# CITY OF ALBUQUERQUE

October 28, 2021

**Re: Cien Aguas Charter School**  
**2501 Buena Vista Dr SE**  
**Traffic Circulation Layout**  
Engineer's Stamp 10-25/2021 (M15-D004B)

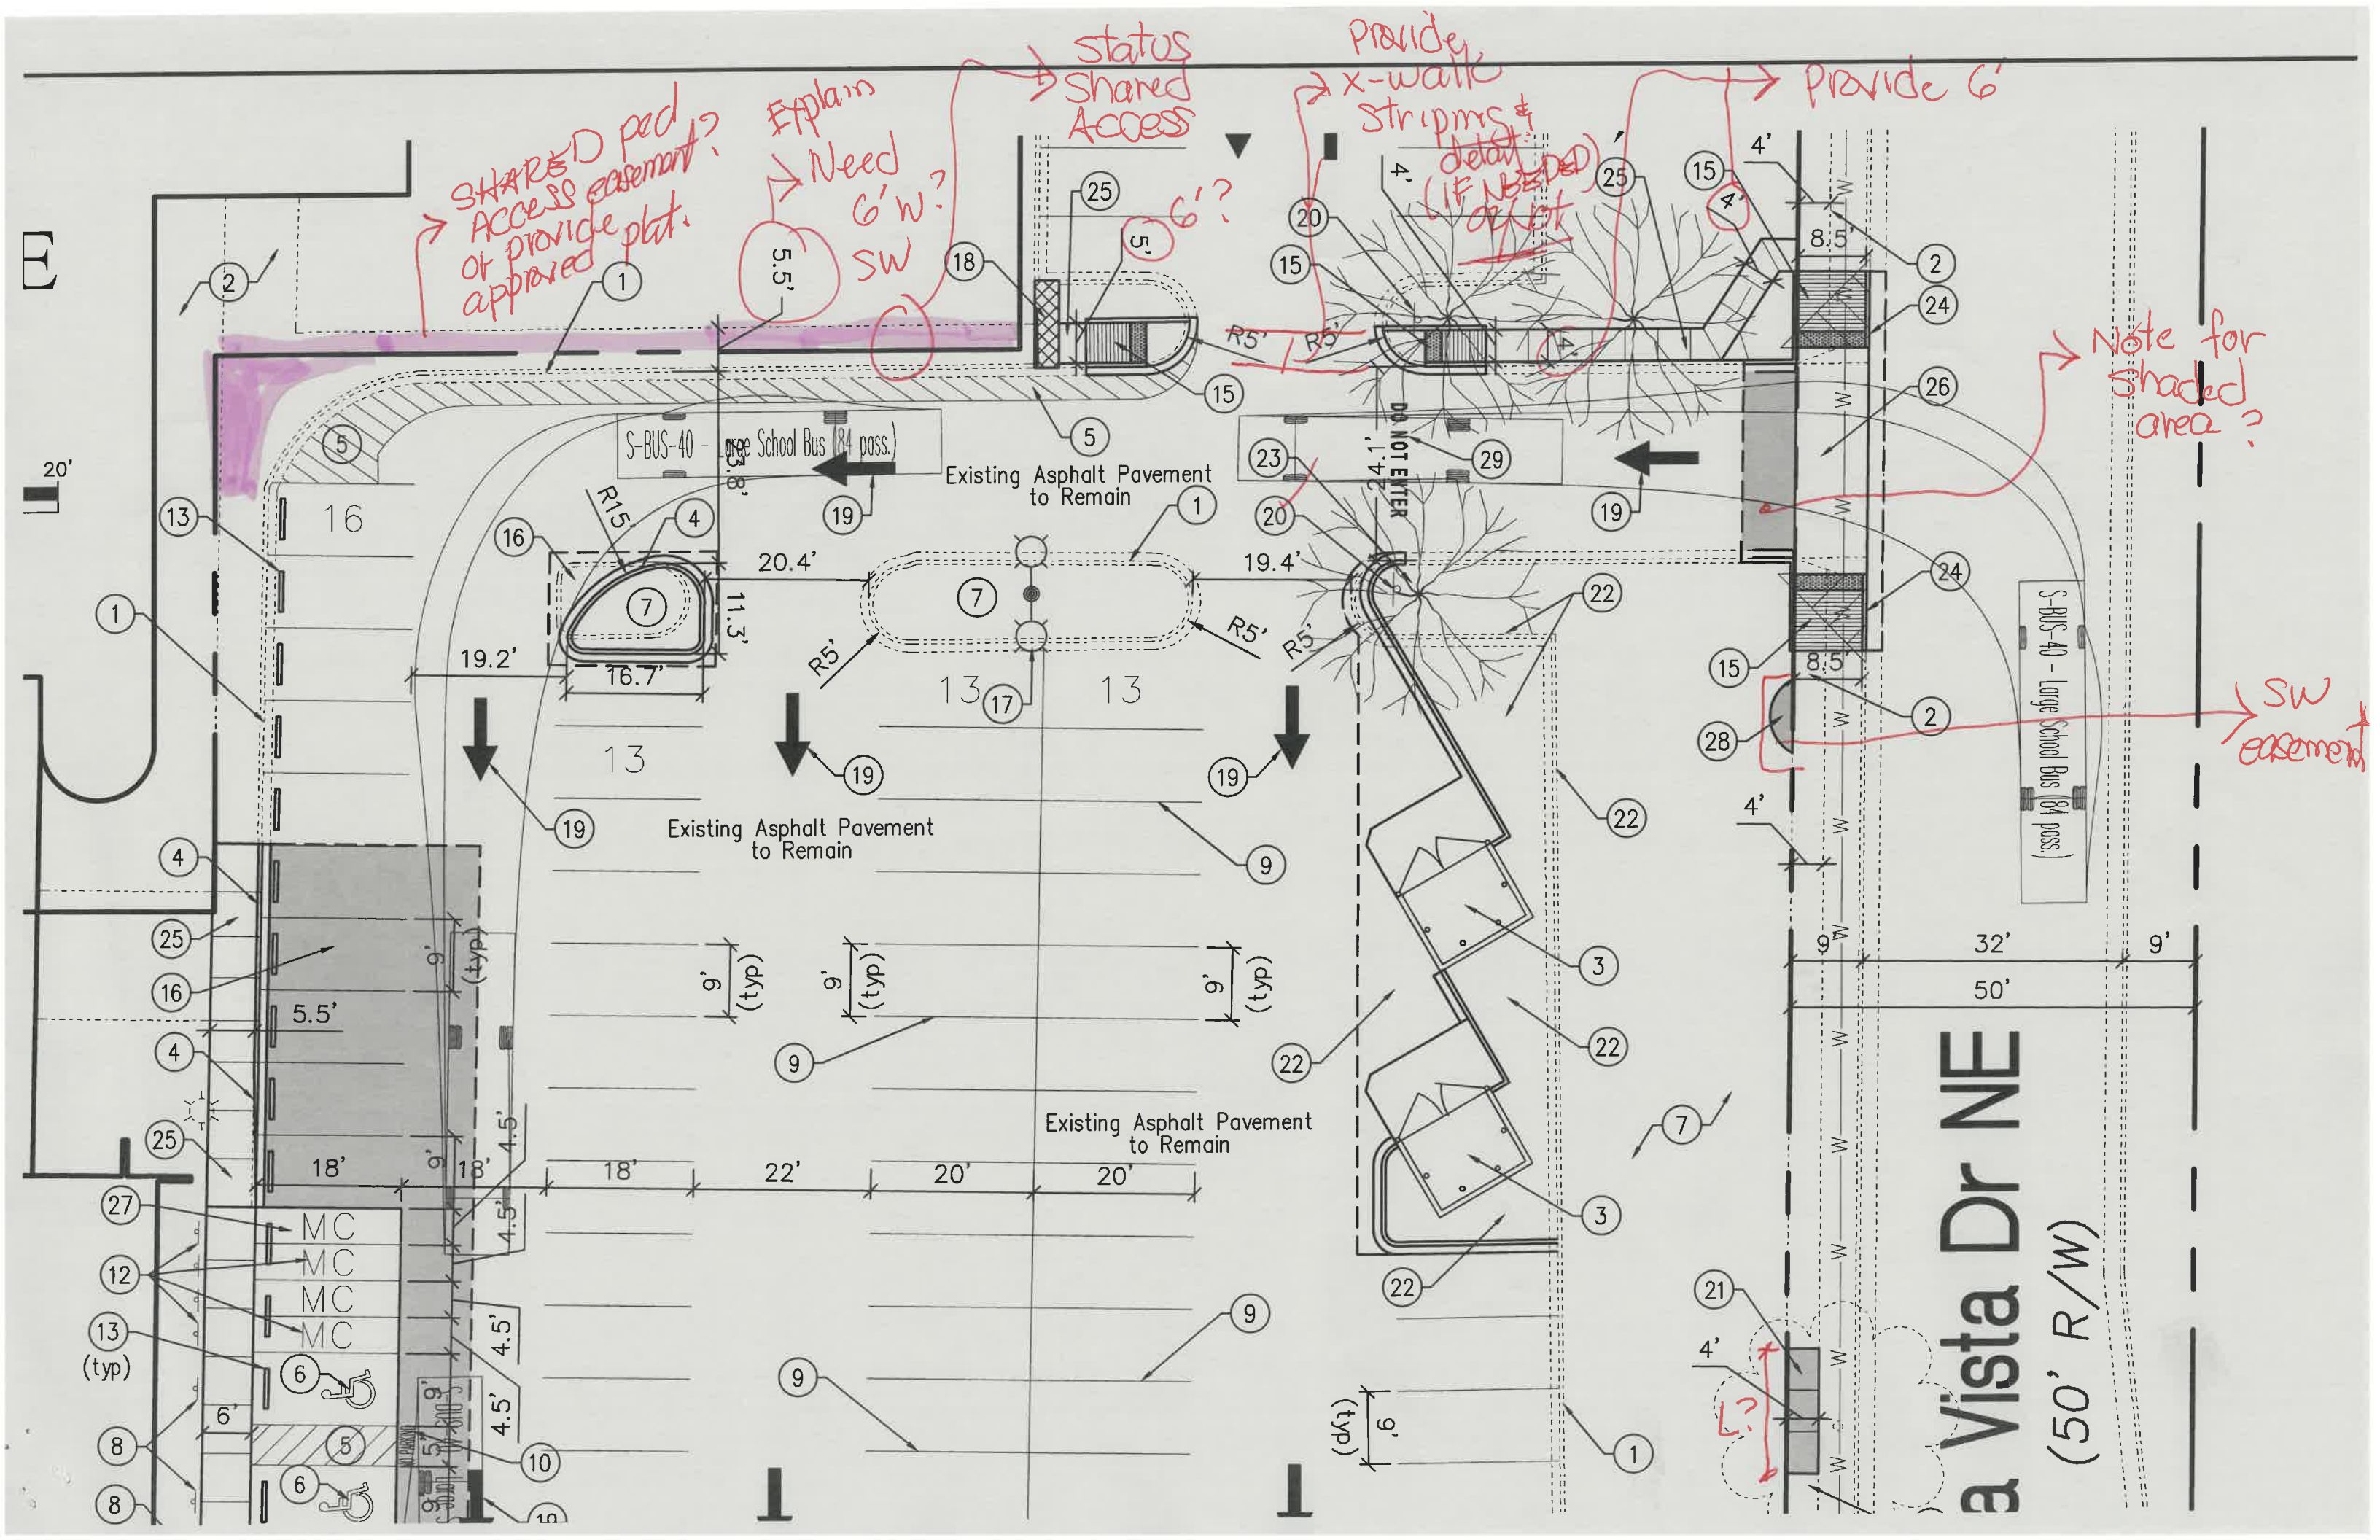
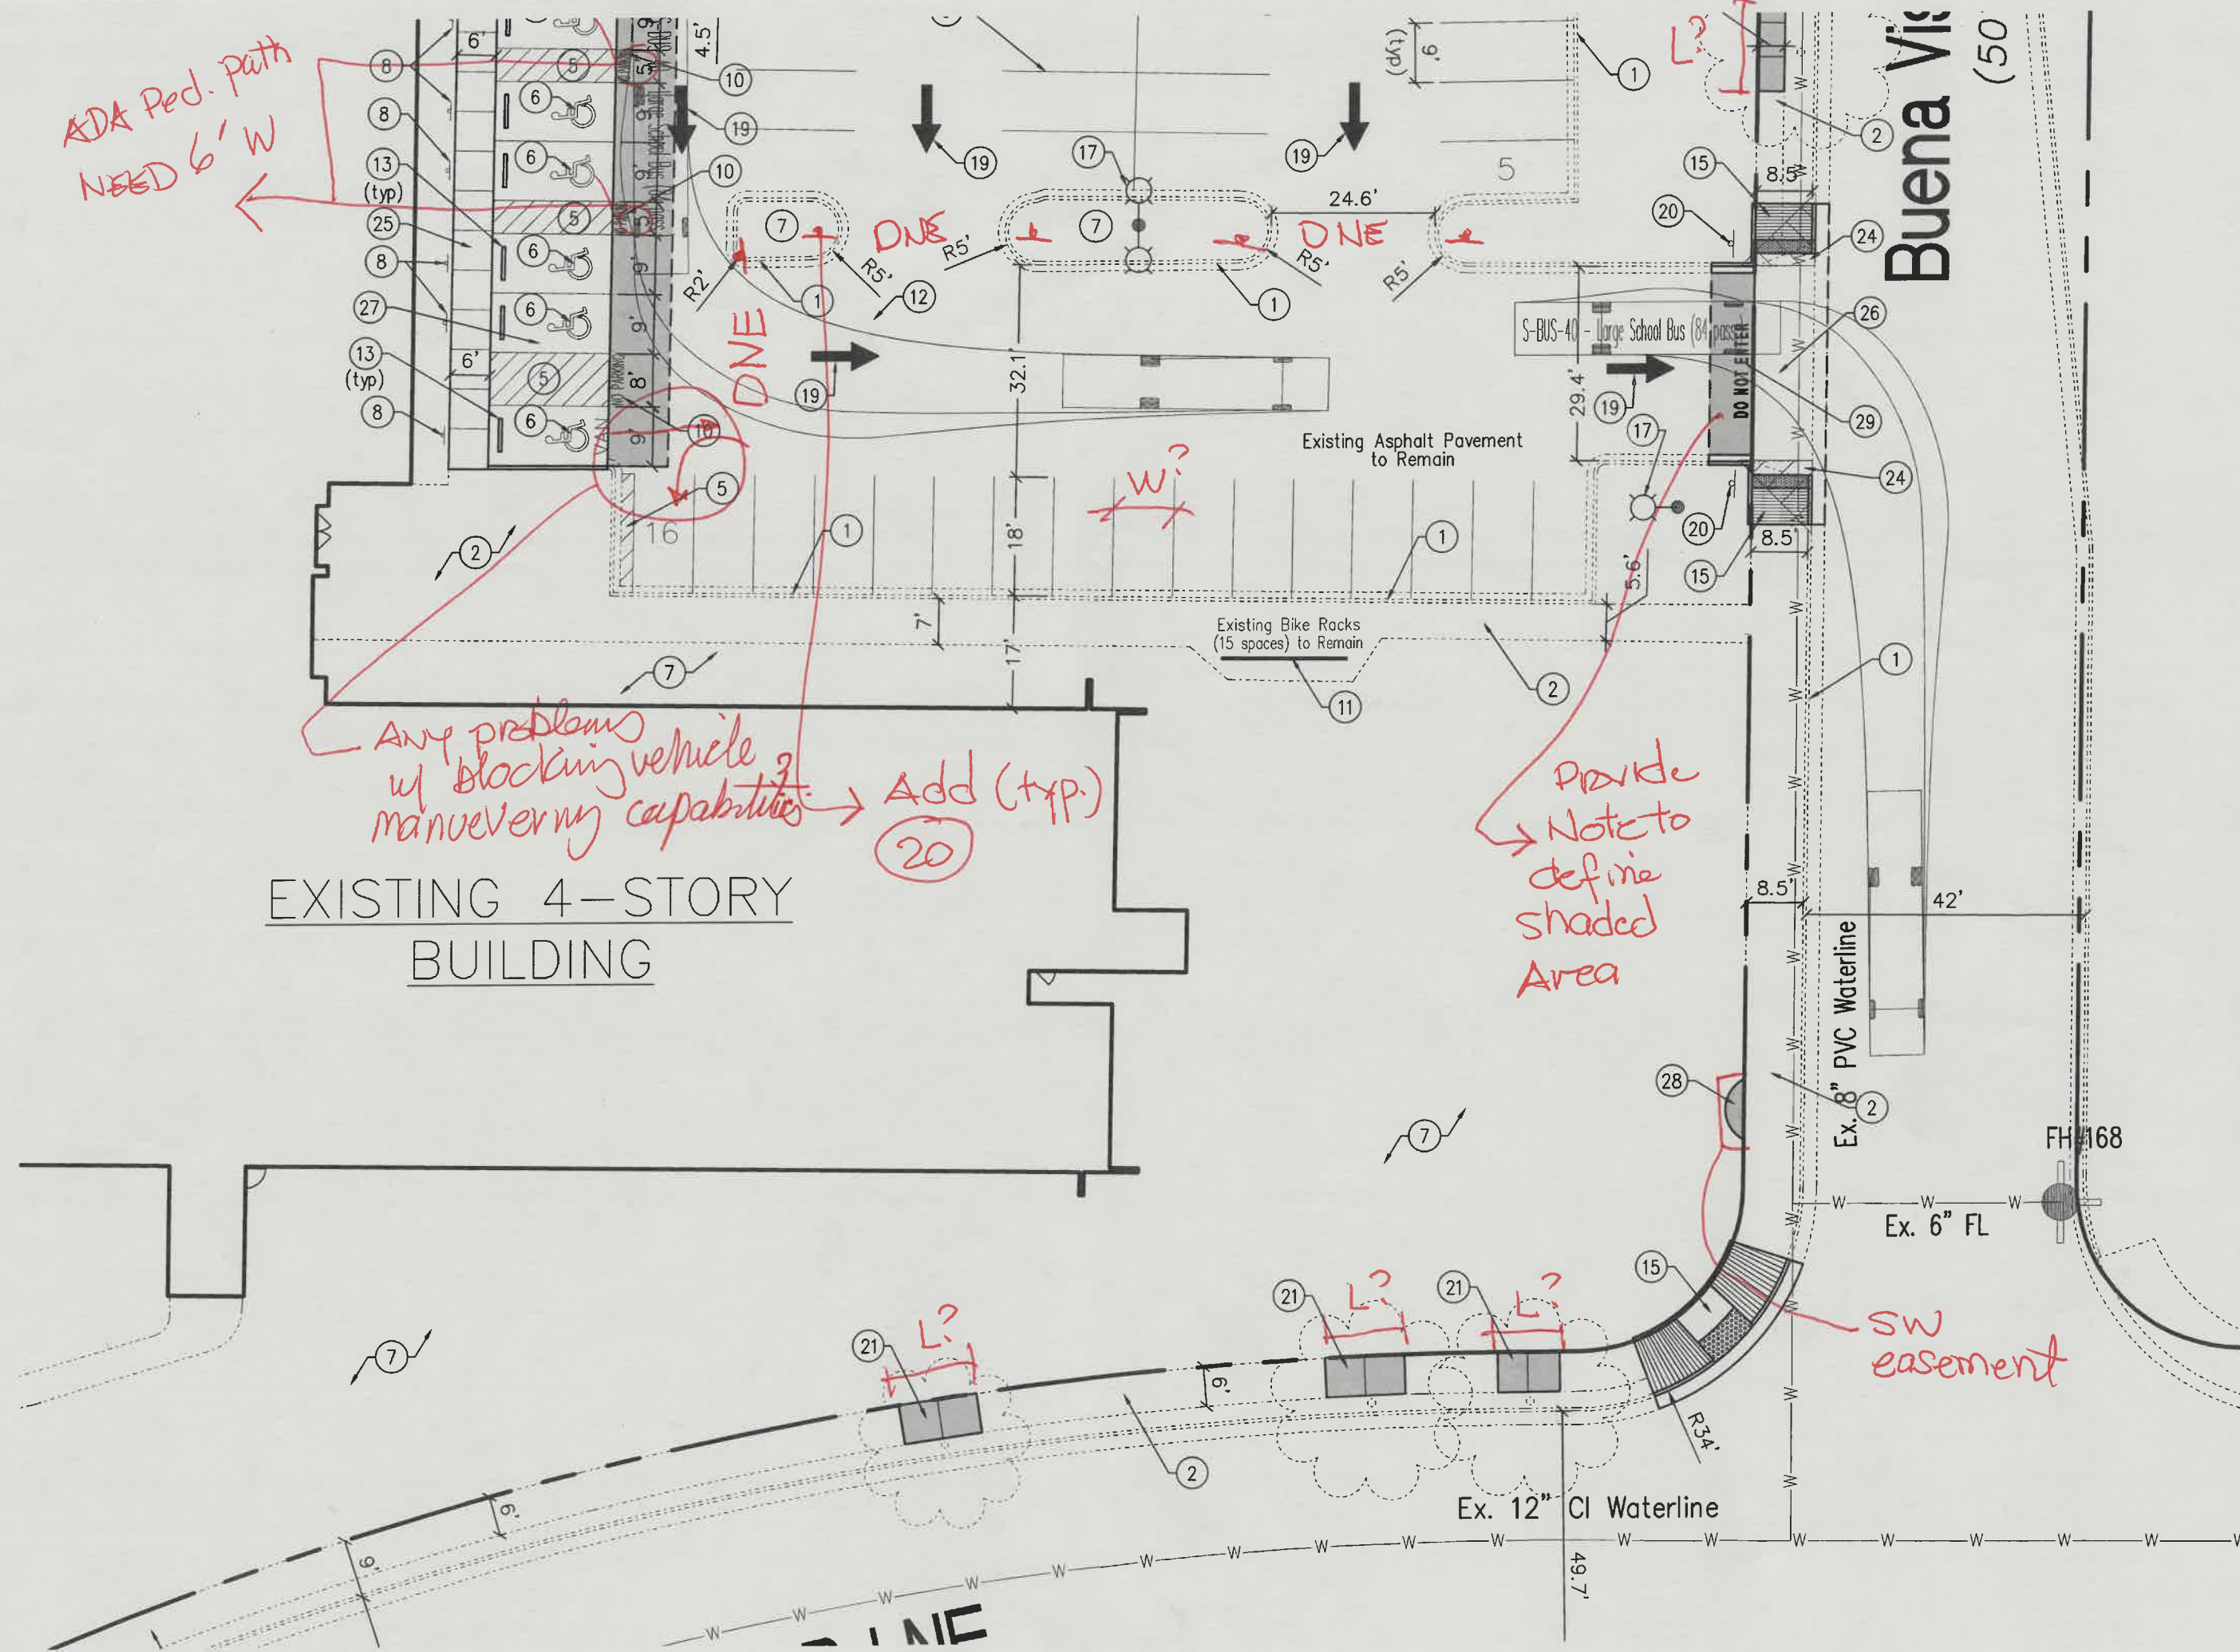
1. Existing driveways/pads serving Overflow Parking off Buena Vista Drive is not ADA accessible, you will need to replace these driveways to comply with the most current/updated design (Reference COA std dwg 2425A&B).

2. Shared access easement is needed and/or provide an approved plat stating blanket easement.
3. Please label/provide note and/or reference detail to substantiate the shaded area behind the driveway modifications as shown on plans.

4. Verify that vehicle maneuverability capabilities are not impacted between regular and ADA parking stalls.
5. ADA curb ramps must be updated to current standards and have truncated domes installed at the corner of Buena Vista/Renard Pl. Construction notes and details will need to be provided.

6. Per the IDO, a 6 ft. wide ADA accessible pedestrian pathway is required from the public sidewalk to the building entrances. **Please explain why only 4 ft and 5.5 ft widths are proposed.**

7. Per DPM, a 6 ft. wide ADA accessible pedestrian pathway is required from the ADA parking stall access aisles to the building entrances. **Explain how this will be complied with only a proposed 5 ft width access aisle for ADA parking stalls.**

8. All one-way drives shall have "One Way" and "Do Not Enter" signage and pavement markings. **This needs to be provided on all 1-way orientation on site.**

11. Sheet C-104: Please reference COA std dwgs for proposed drivepad modification details.
12. Please provide a letter of response for all comments given.
13. Resubmittal fee pavement receipt will need to be provided.
